**Consultation Response from KC,  
Highways Development Management**

**2026/91103 Dry Hill Farm, Dry Hill Lane, Denby Dale, Huddersfield, HD8 8YN**

**Erection of detached dwelling with garage, formation of driveway off existing entrance and gardens**

**Date Responded: 11 June 2026**

DRAWING DESCRIPTION
 PROPOSED FLOOR PLANS AND ELEVS PLOT 5

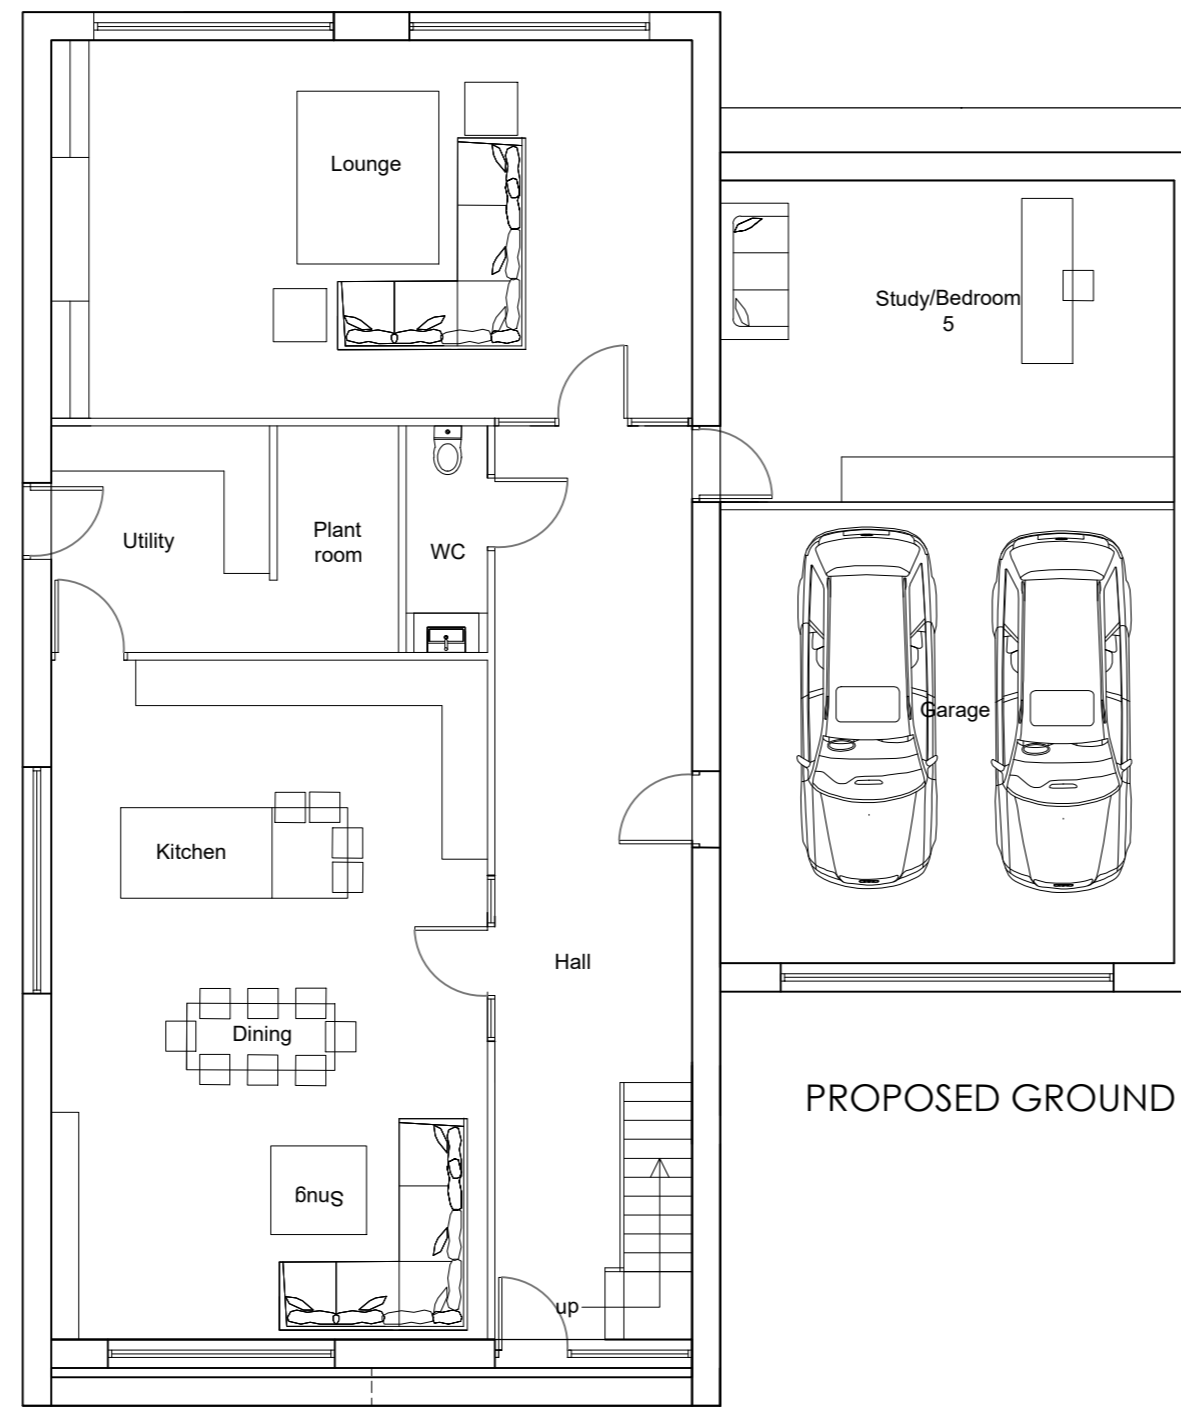
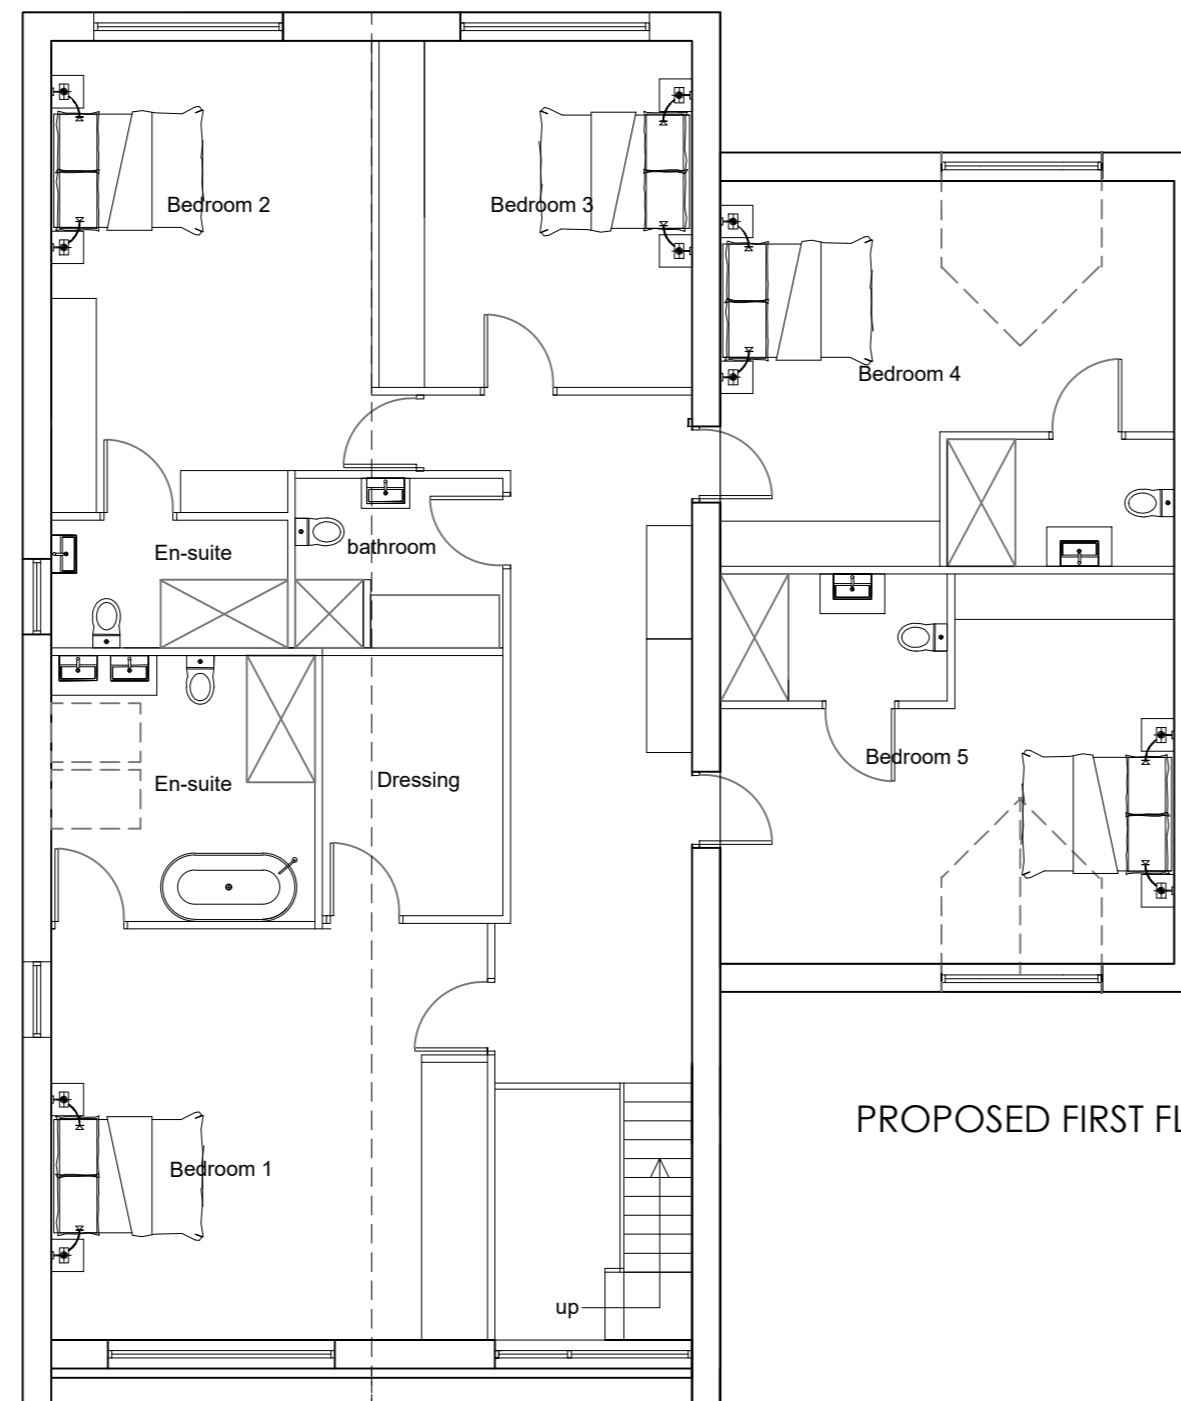
To support mode choice, policies LP20 and LP22, as well as Active Travel, cycle parking can be accommodated within the proposed integral garage as recommended in the Kirklees Highway Design Guide SPD.

The integral garage is of adequate size with an internal dimension of 6.1 x 6.0m sufficient to count towards car parking and the storage of cycles and other items.

DRAWING DESCRIPTION
PROPOSED SITE PLAN PLOT 5

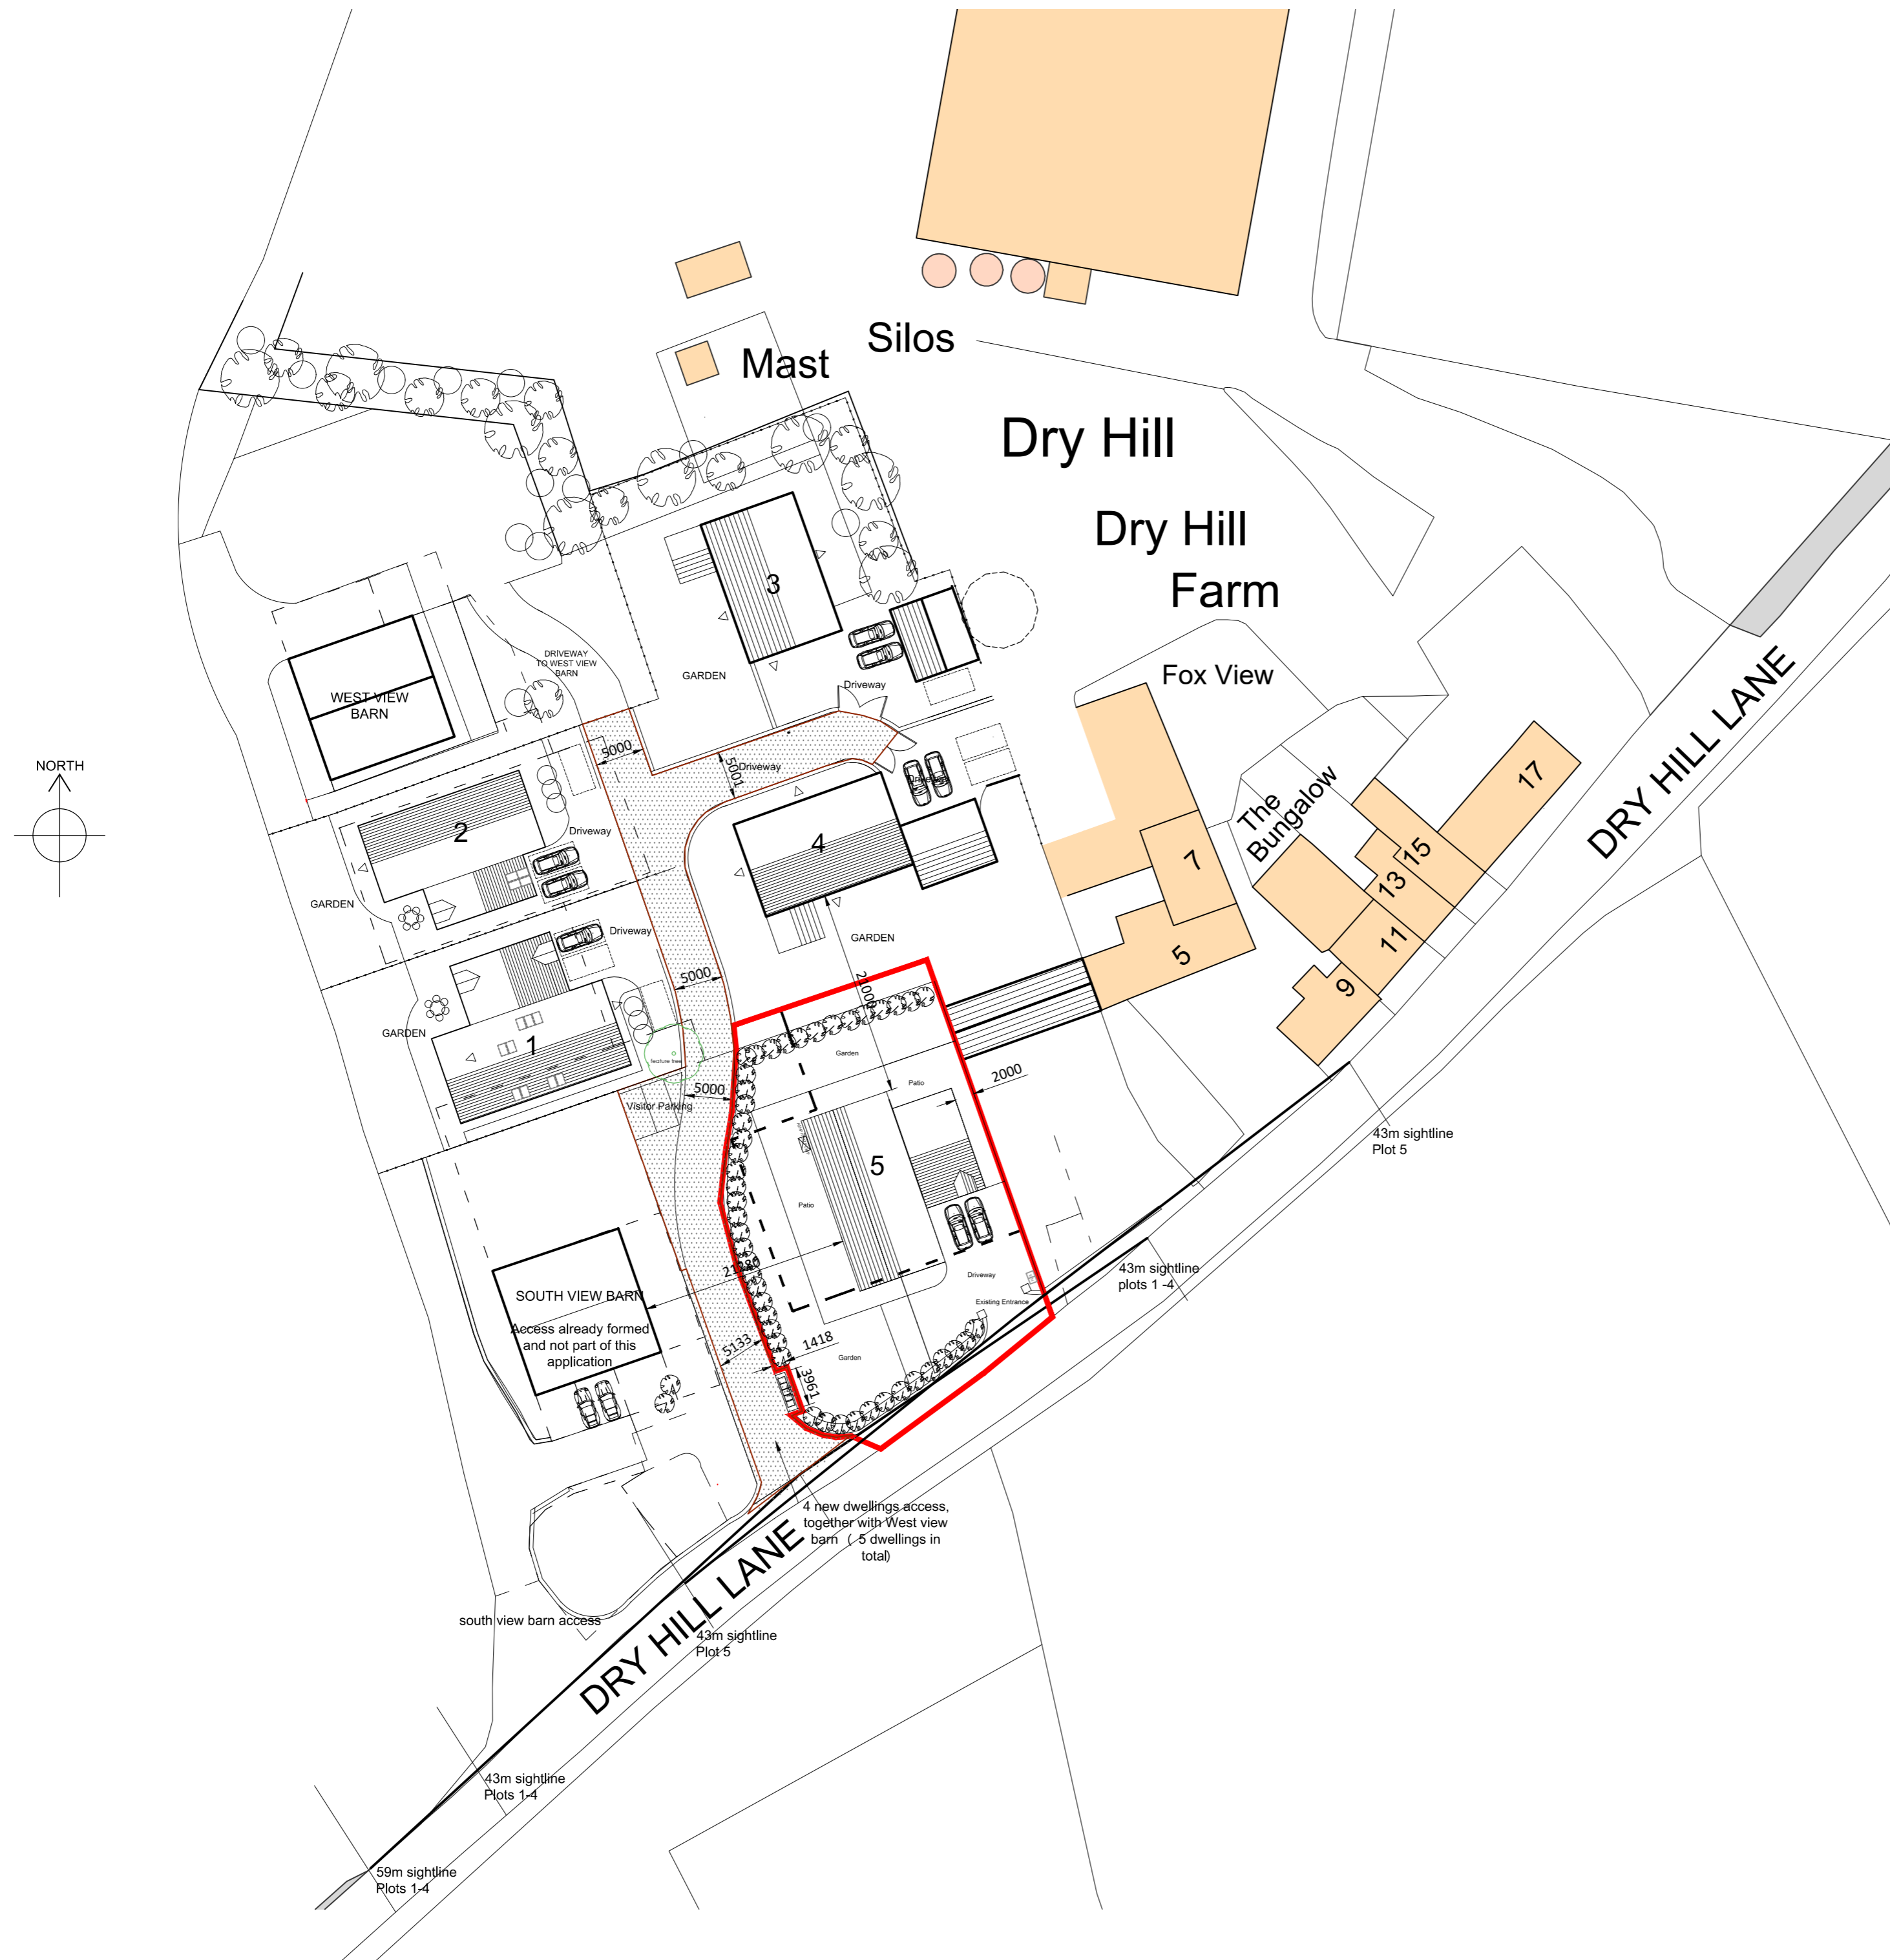
The existing gated access is to be modified by widening to c4.8m on removing the gate and part of the adjacent boundary wall. This would allow bi-directional movement and shared use with pedestrians.

The connection to the highway to better align with the access and should be appropriately surfaced to the Kirklees specification This will require a separate permission from Highways. Refer: <https://www.kirklees.gov.uk/beta/transport-roads-and-parking/dropped-kerbs.aspx>

The visibility splays of 2.4 x 43m in each direction have been accepted previously in this location despite the 60mph speed limit, but these are not drawn from the midpoint of the existing access. Instead, appear to relate to intended access position for the refused planning application 2025/62/90001/E as well as the access junction to the south. A revision is necessary and for it to be resubmitted for approval.

Within the site the scheme proposes a driveway and an area of concrete hardstanding leading to the main entrance of the proposed dwelling and integral garage for off-street parking. An area for bin storage is indicated.

The concrete surfacing should be of a permeable type of surface water drainage provided with a scheme to be submitted for approval.

There would be space for at least four cars with two to be parked in the integral garage. The amount of car parking is above the suggested requirements outlined in the KHDG SPD for a four plus bedroomed dwelling of three spaces but would allow for flexibility in line with policy LP22 such as for visitor provision.

Additionally, the area of hardstanding allows for turning within the site to facilitate entry and exit in a forward gear.

There is adequate space for bin storage for roadside collection.

- a) Electric vehicle charging point: Development shall not be occupied until Electric Vehicle Charging Points have been provided in accordance with a scheme that shall have been submitted to and approved in writing by the Local Planning Authority. The approved facilities shall thereafter be retained for the lifetime of the development.

- b) Areas to be surfaced and drained: Prior to the development being brought into use, the approved vehicle parking areas shall be surfaced and drained in accordance with the Communities and Local Government; and Environment Agencies 'Guidance on the permeable surfacing of front gardens (parking areas)' published 13th May 2009 (ISBN 9781409804864) as amended or superseded; and thereafter retained throughout the lifetime of the development.
